Our ref: Waste Management Facility, Botany (SSD-62855708)

Subject: Request for Additional Information

I refer to the Submissions Report for the Waste Management Facility, Botany, State significant development (SSD) application (SSD-62855708). The Department of Planning, Housing and Infrastructure (Department) is reviewing the Submissions Report in consultation with relevant government stakeholders, including Bayside Council (Council). Advice received from government authorities has been forwarded to you for consideration and response.

The Department has reviewed the Submissions Report and requests the following matters regarding the assessment of traffic impacts be addressed as part of a consolidated response to the matters raised by the government authorities. These comments relate to the Traffic Impact Assessment prepared by Traffix dated 20 March 2025, Version 14, submitted as Appendix C to the Submissions Report.

APPENDIX 1 – Swept Path Analysis Diagrams

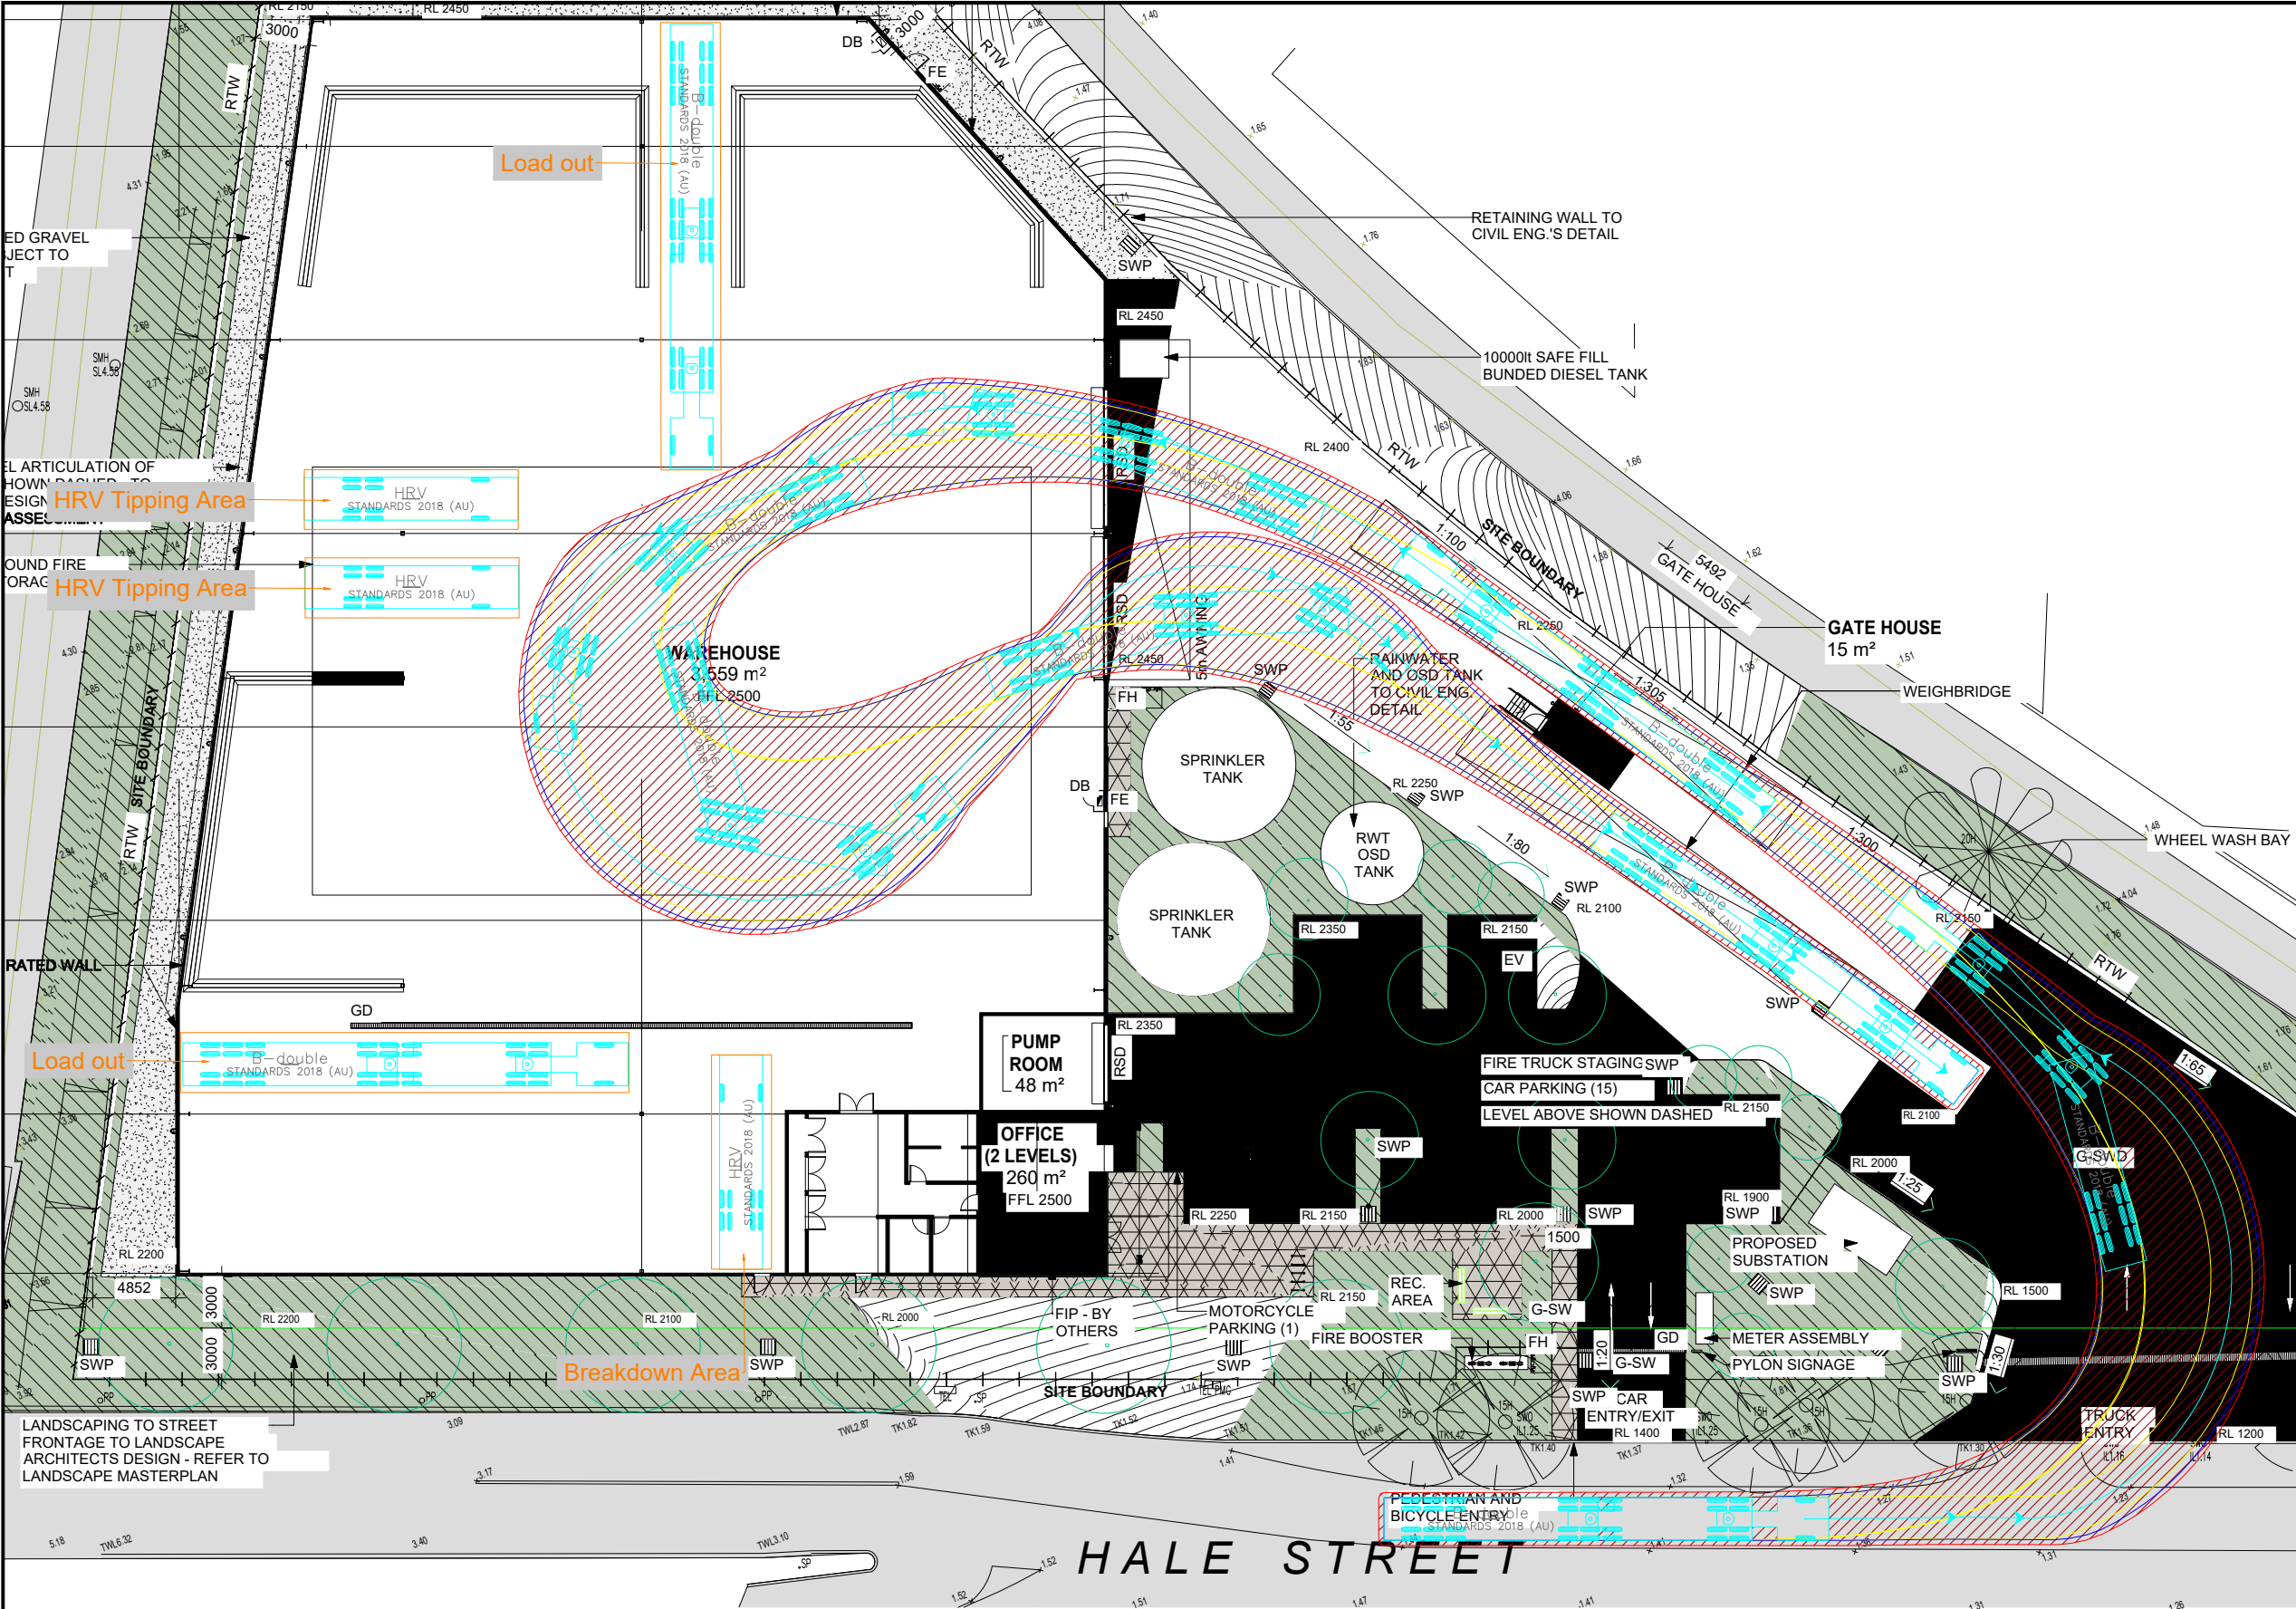
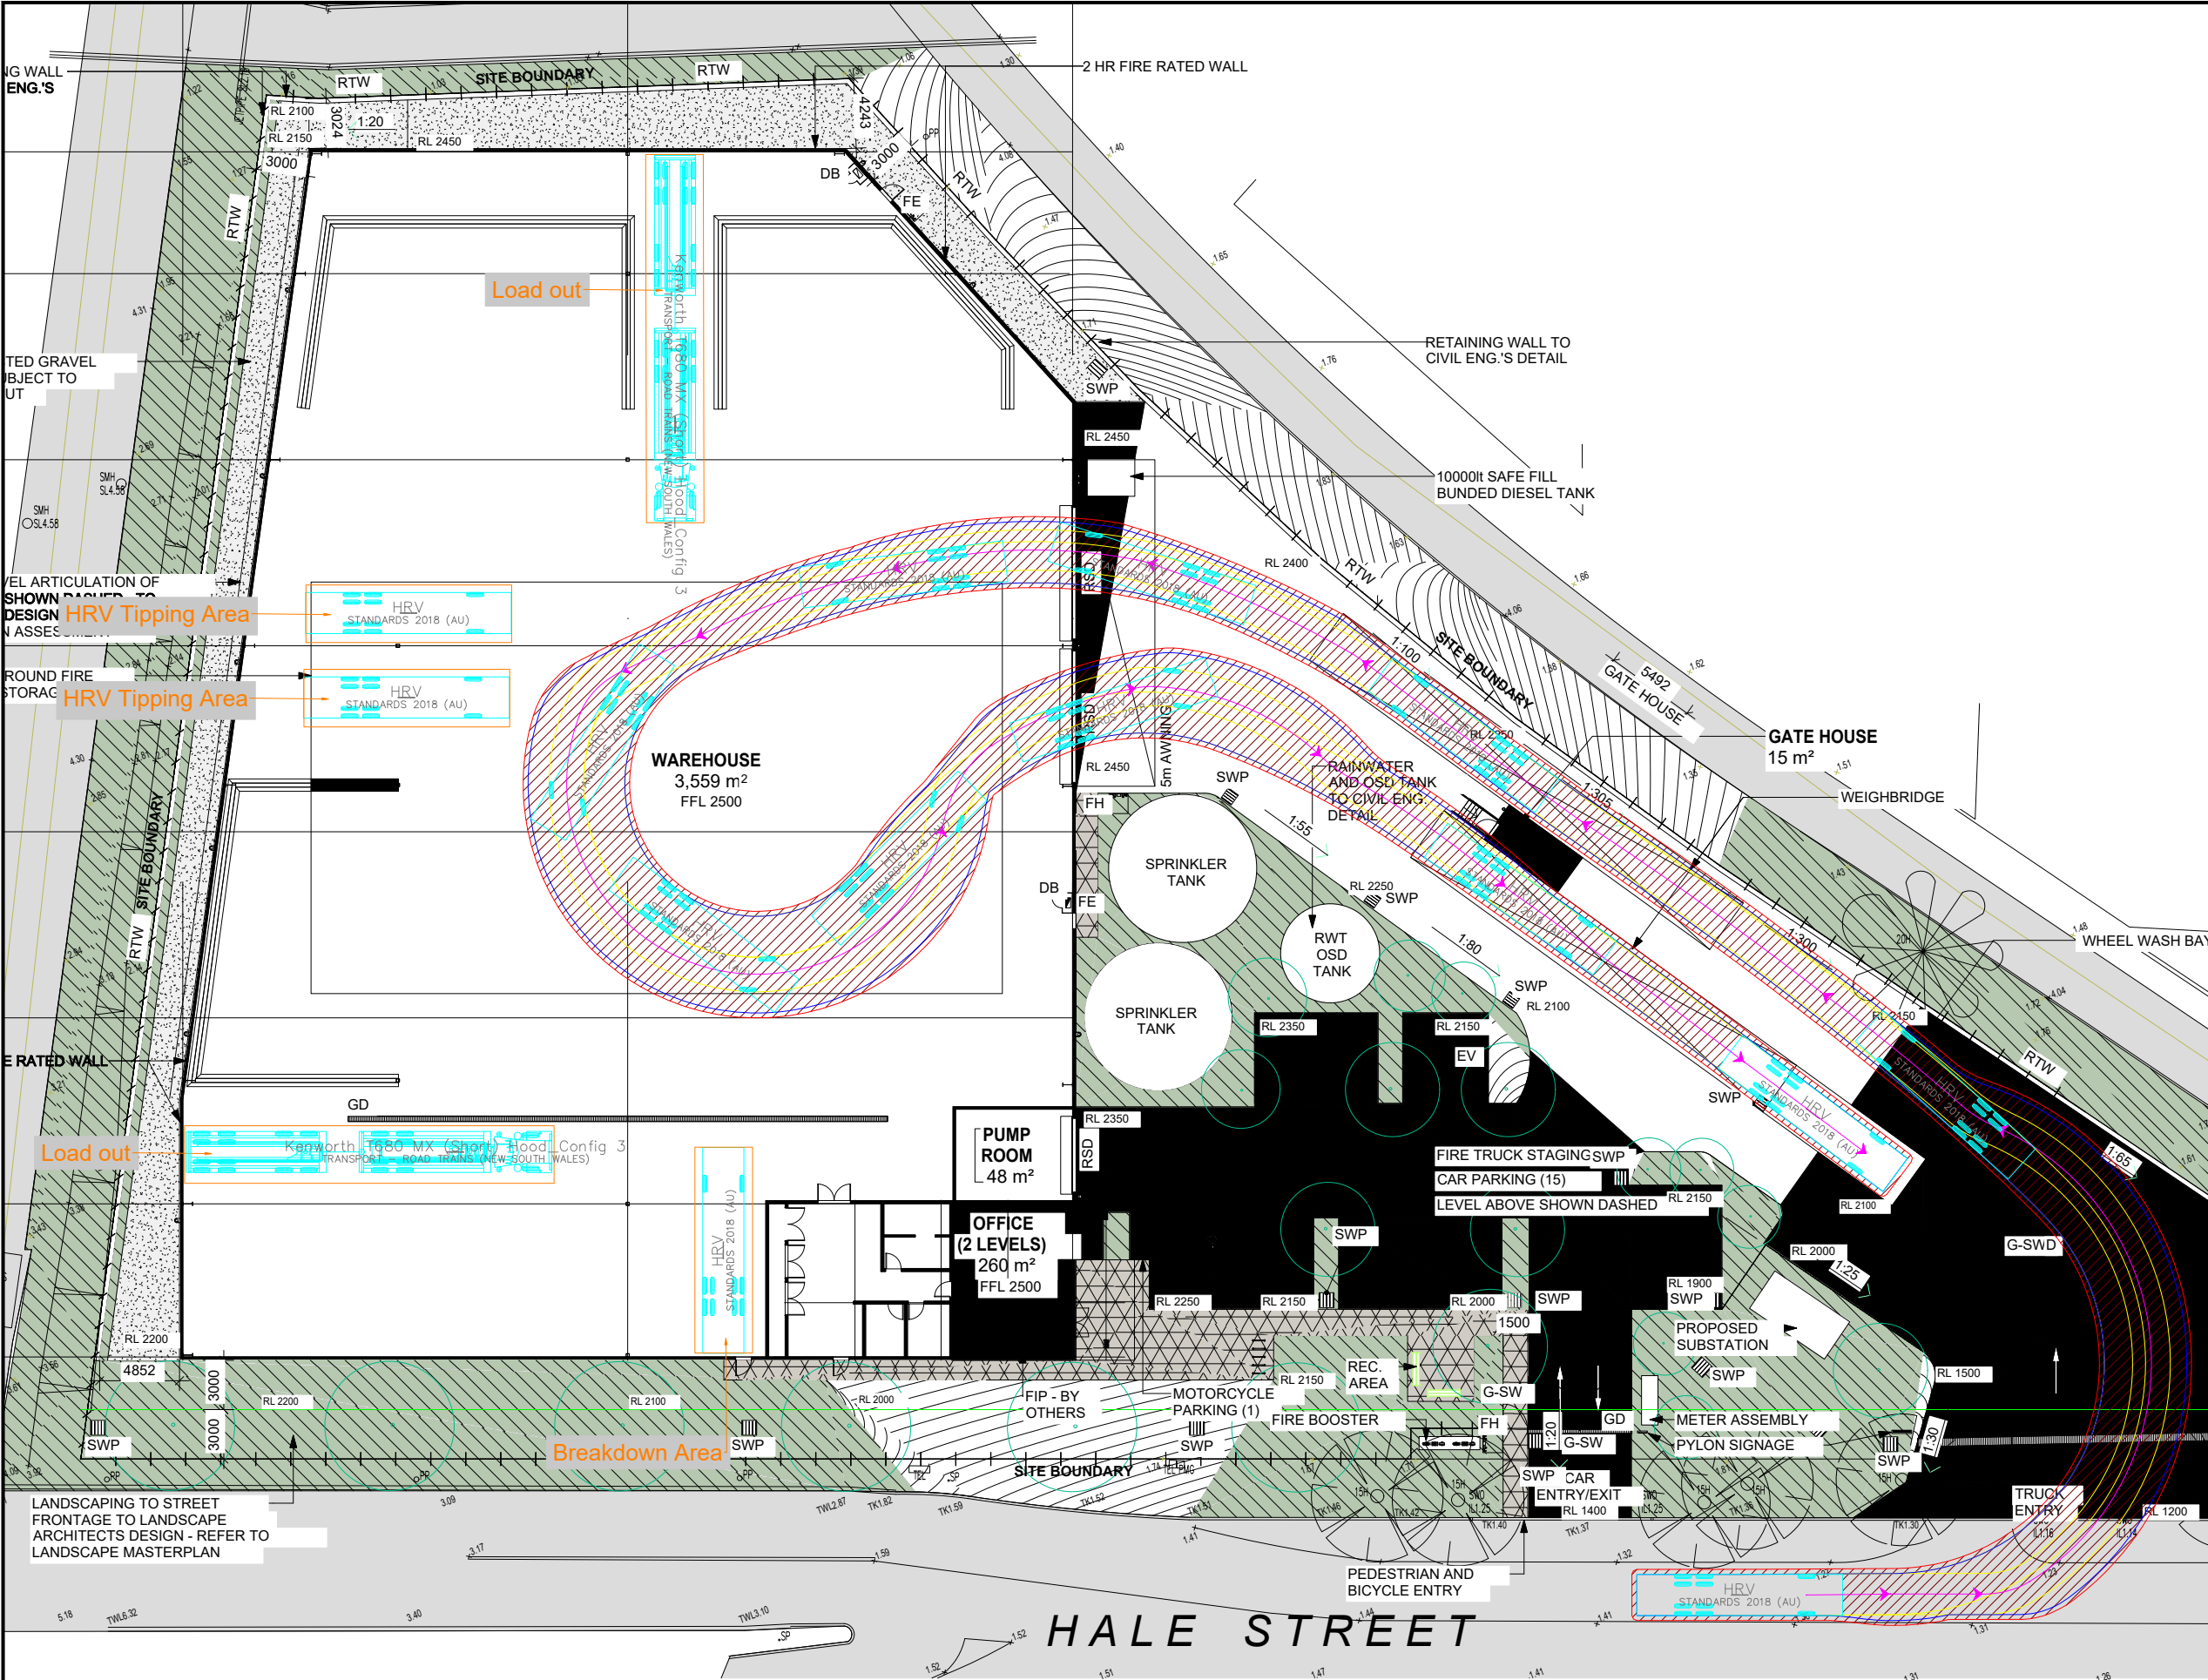
- The swept path analysis shows the movement of a B-double exiting the site on a separate drawing to the swept path of a B-double accessing the site. It is not possible to determine if there will be any conflicts if these two movements occur simultaneously. Please provide a plan that shows a B-double entering and exiting the site simultaneously demonstrating that this movement can occur safely and without any conflict to either vehicle or on-street parking, and without crossing the centreline of Hale Street.
